Appeal Decision

Appeal Ref: APP/T2350/W/16/3148135

1&2 Abbeycroft, The Sands, Whalley BB7 9TN

- The appeal is made under section 78 of the Town and Country Planning Act 1990 against a refusal to grant planning permission.
 - The appeal is made by Mr Peter Fletcher against the decision of Ribble Valley Borough Council.
 - The application Ref 3/2016/0022, dated 7 January 2016, was refused by notice dated 25 February 2016.
 - The development proposed is demolition of external toilet block and the construction of a single storey extension at the rear of 1 & 2 Abbeycroft.
-

drawing title:  
 EXISTING AND PROPOSED DRAWING

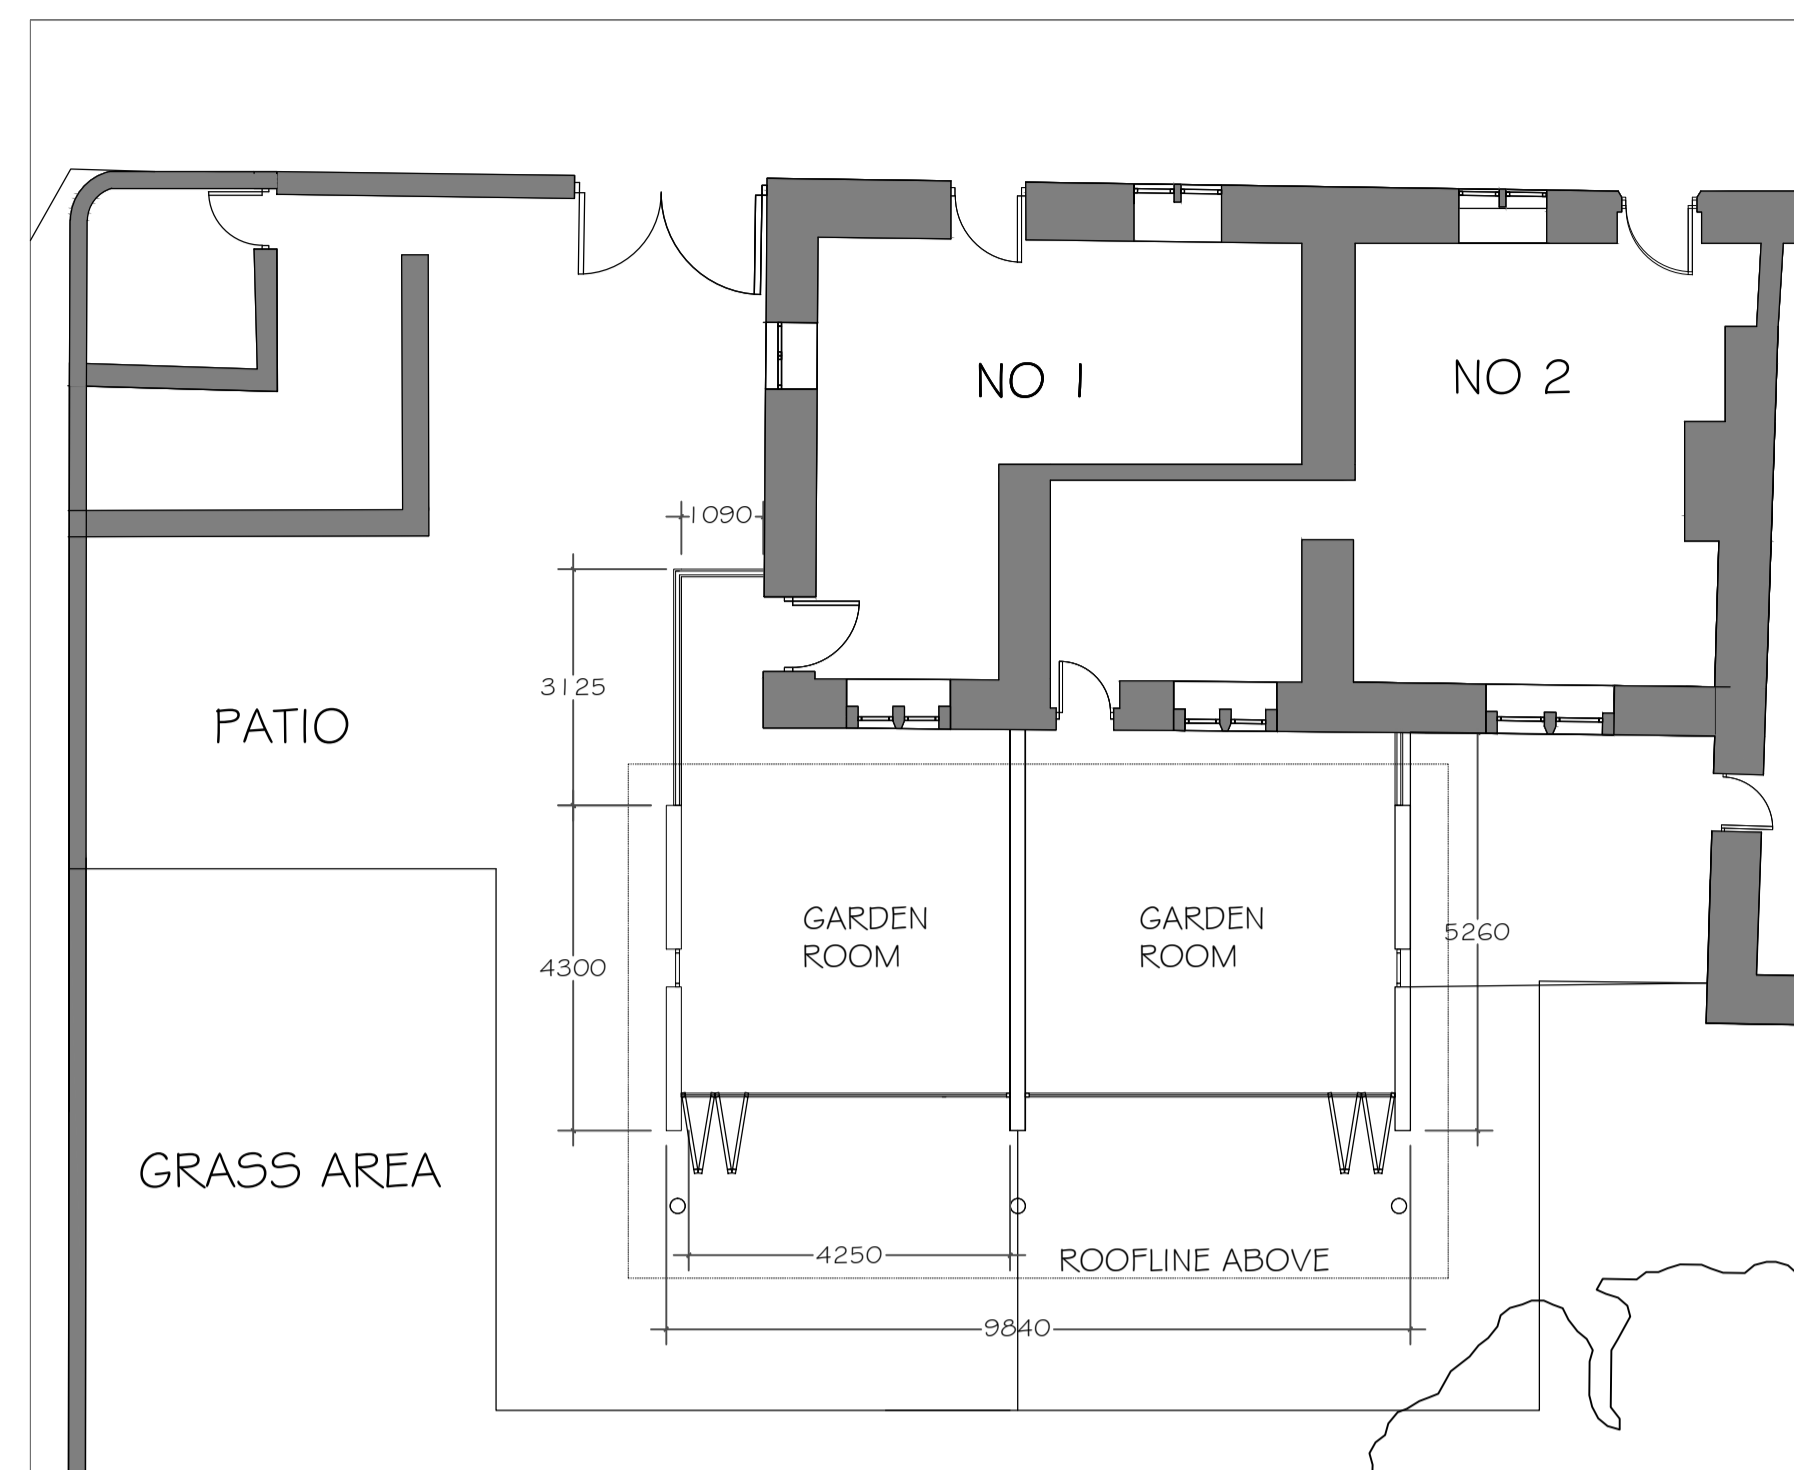
7. However, the structure would be almost double the depth of the existing building and would extend some way beyond the existing two-storey projection, itself a substantial element of the building. In addition, the wrap around style of the extension would be at odds with the linear form of the building as a whole. Whilst I acknowledge that the height of the extension would be significantly lower than that of the host building, at almost 3m high and of the depth proposed it would, nevertheless, be a sizeable structure. As a result of its position and size, coupled with its contemporary character, it seems to me that the extension would draw the eye and would compete with, rather than be visually subordinate to, the character of the listed building.

8. Furthermore, the extension would project forward of the side elevation towards The Sands and thereby be an obvious and prominent feature in the public realm. I accept that the stone boundary wall would partly obscure views of the extension. Nevertheless, the height of the wall is not consistent and parts of the extension would be visible for a considerable distance along The Sands in both directions. The presence of the extension would also be apparent at night when illuminated. Whilst I accept that the extension would extend across only part of the terrace as a whole, for the reasons above, I am not persuaded that it would be a sensitive addition.

9. For these reasons the proposal would fail to preserve the special architectural and historic interest of the listed building, or the setting of neighbouring listed buildings. In addition, the proposal would not preserve the character or appearance of the conservation area. Consequently the proposal would not meet the requirements of s66 (1) and s72 (1) of the Planning (Listed buildings and Conservation Areas) Act 1990 (the Act).
